KITTITAS COUNTY FIRE MARSHAL'S OFFICE

July 22, 2011

Re: Bower's Field (BL-11-00013)

After conducting a review of the above named project, I have the following comments:

BL-11-00013 Bowers Field Existing

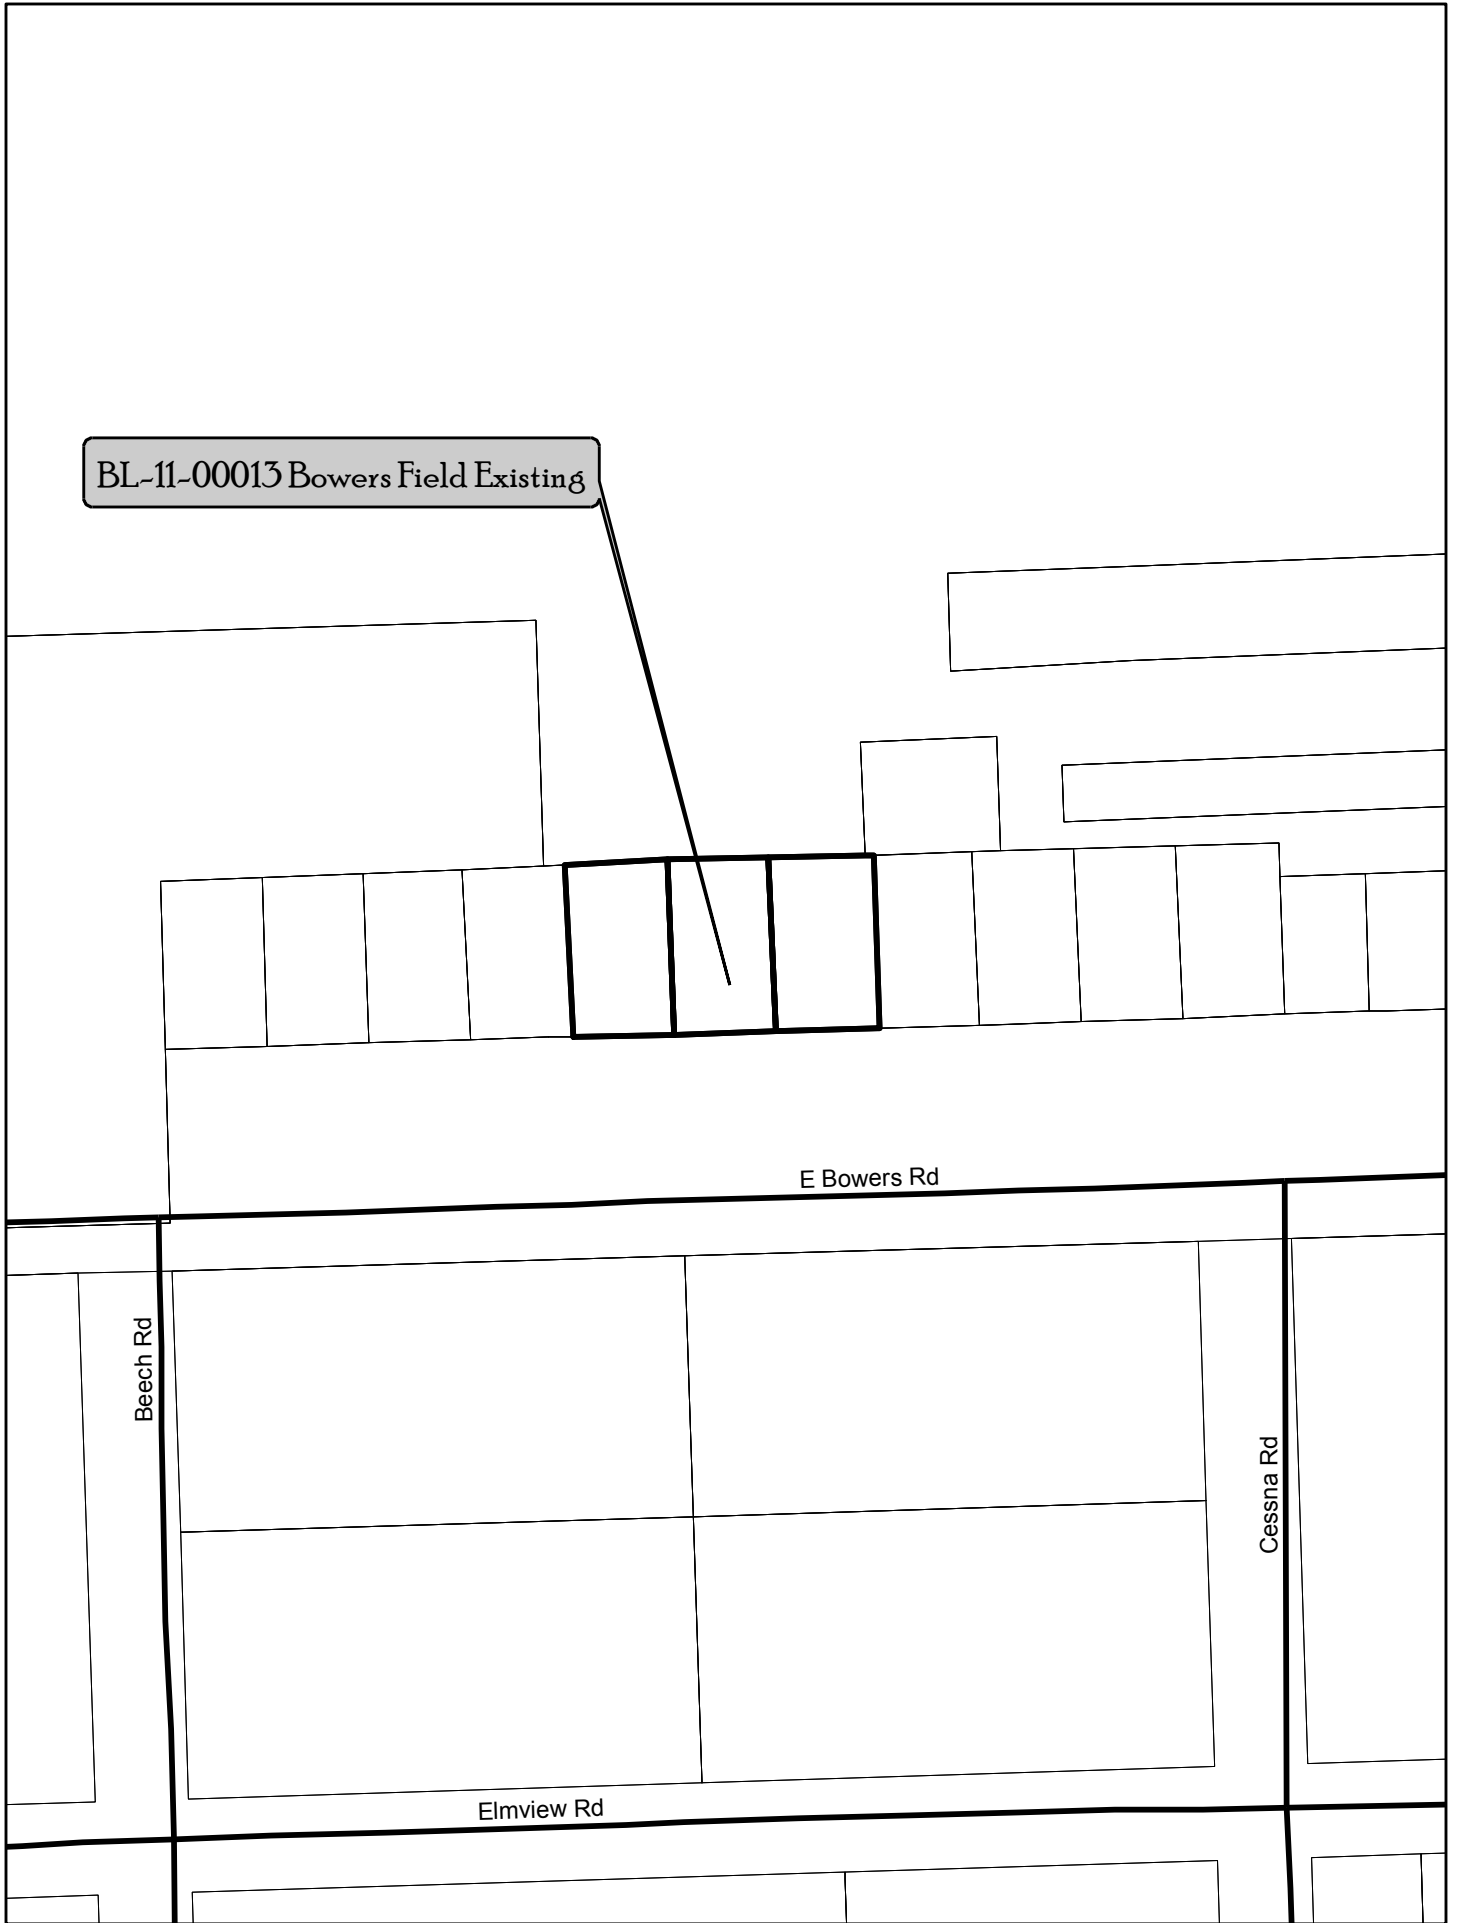
- Ensure that boundary line adjustments do not infringe upon existing structures, to include propane tanks, etc.
- Creation of any additional roads or access must comply with the International Fire Code.
- All future development must comply with the International Fire Code.
